TECHNICAL NOTE

DATE:	01 November 2022	CONFIDENTIALITY:	Public
SUBJECT:	Site A – Response to Drainage Officer Comments		
PROJECT:	Bognor Golf Course	AUTHOR:	Andy Smith

This Technical Note has been produced to provide a detailed response to the Drainage Officers comments on the surface water drainage strategy for Site A which was developed to support the Hallam Land Management Ltd's planning application for the redevelopment and relocation of the existing Golf Course (planning app ref: M/16/22/PL and FP/274/21/OUT).

Figure 7-1 - SuDS Location Plan

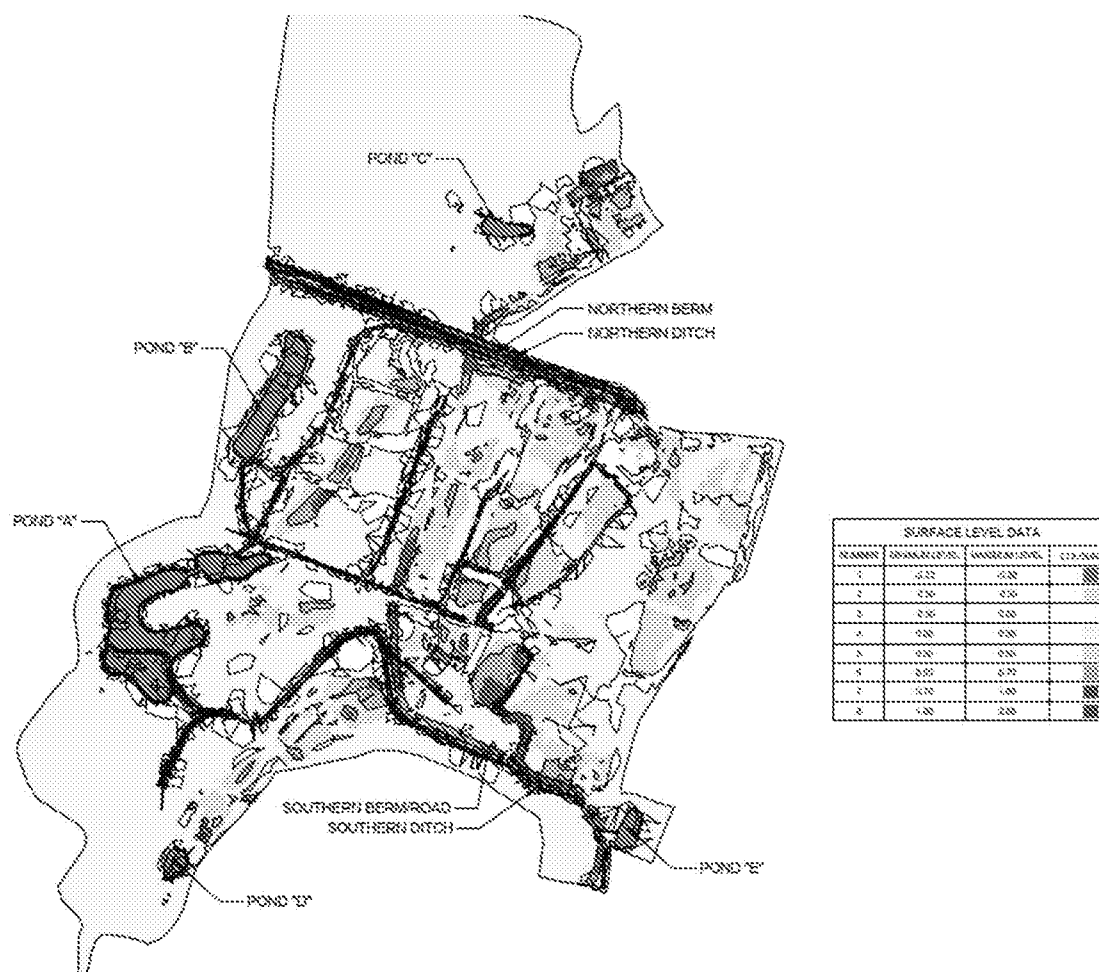
3 - No clear surface water drainage proposals are provided for either site. We appreciate that proposed 3D ground modelling is provided but more information needs to be provided on where the proposed development impermeable areas are draining to, attenuation provisions and where the surface water is ultimately being discharge to. The surface water calculations need to be provided to demonstrate that the run-off from these areas can be accommodated within the proposed attenuation features. In addition, clear information on the modelled fluvial flood level in relation to the attenuation features needs to be provided and surface water calculations need to demonstrate the impact of joint probability events. This is to ensure that the quantum of development proposed at outline stage is achievable and that the surface water drainage proposals comply in not increasing the risk of flooding elsewhere or onsite. In addition to this the locations of the proposed SuDS must clearly be outside of the impacts of the modelled fluvial flood extents.

For ease of interpretation the surface water drainage strategy is described below and shown on an attached plan:

- The flood management strategy removes any off site flood waters from the development platform, through the use of a berm to the north and a realigned watercourse / raised site access road to the south. Any waters remaining are minor and can easily be addressed at the detailed design stage through one or more of lowering the adjacent road, slightly raising the impacted development parcel, creating a bund and swale, if any inundation remains once further consideration has been given to the proposed levels;;

- Surface water runoff from the development parcels drains into a network of swales and ditches through the site (these will be enhanced as required, which may include re-grading, widening etc);

- These swales direct water to a series of ponds;
- The Pond A is the attenuation basin which discharges the runoff at controlled rates into the rife
- Pond B is an additional pond which supplements the attenuation storage available in Pond A during outfall locking events; and

- Ponds C and D provide additional attenuation and water quality treatment for the development parcels to the north and the south which cannot connect to Pond A.

Figure B-1 - Storage Requirements

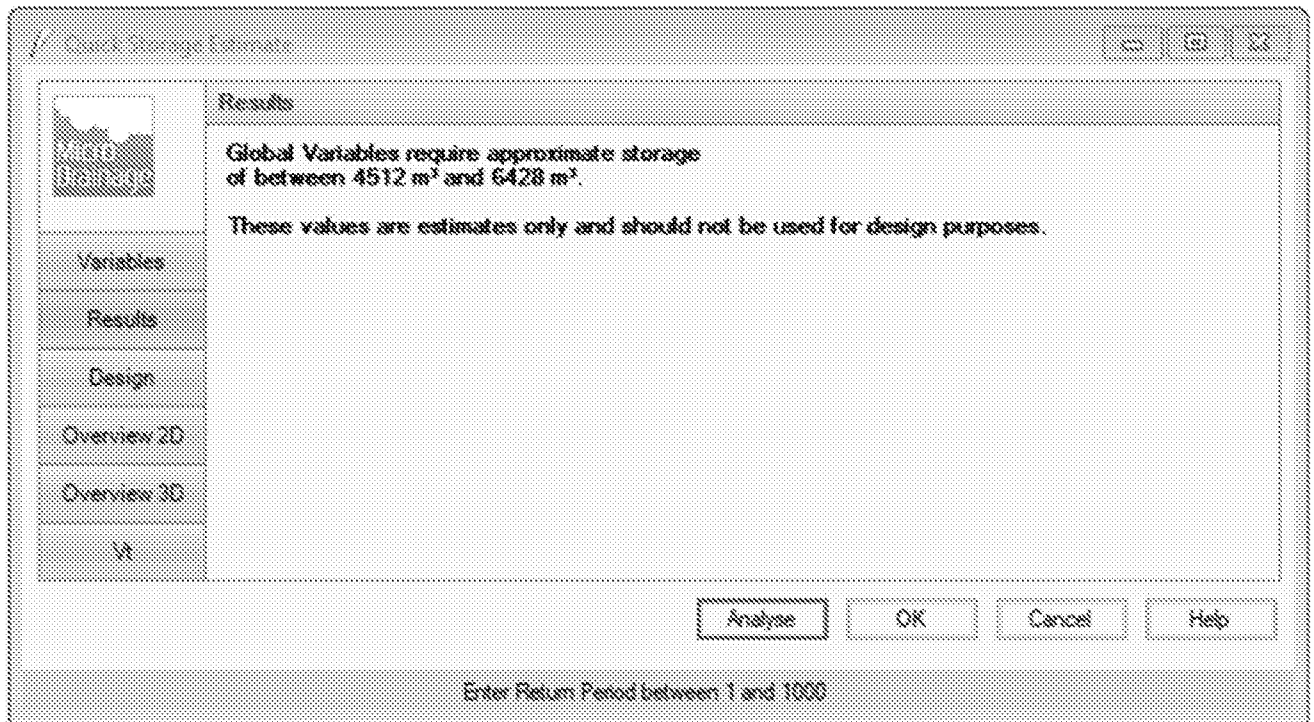
2 - The Modelling report (March 2022) appears to be mixing the fluvial modelling climate change requirements with surface water climate change requirements. DEFRA guidance requires peak rainfall intensity to be considered for 100-year lifetime for a residential development and as since this takes the life of the development beyond 2100 should be using the upper end factor of 45% not 25%.

There are differences in the approach to the calculation of storage volumes between the Surface Water Drainage Strategy submitted at the time of the planning application and this revised strategy, which has been updated to reflect the latest guidance and the advice from the LLFA. The main difference is an increase in storage volume from 6,428m³ to 7,619m³, which reflects changes in the peak discharge rate,

climate change allowances and inclusion of a complex control. A complex control is now incorporated within the design to ensure that the runoff from the impermeable areas is attenuated to greenfield rates and that the runoff from the remaining permeable areas within the development area (i.e. that between the northern berm and the southern road) can also be discharged at the greenfield rates, as there is no requirement to attenuate the runoff from permeable areas (as the pre and post scheme runoff rates would not be altered).
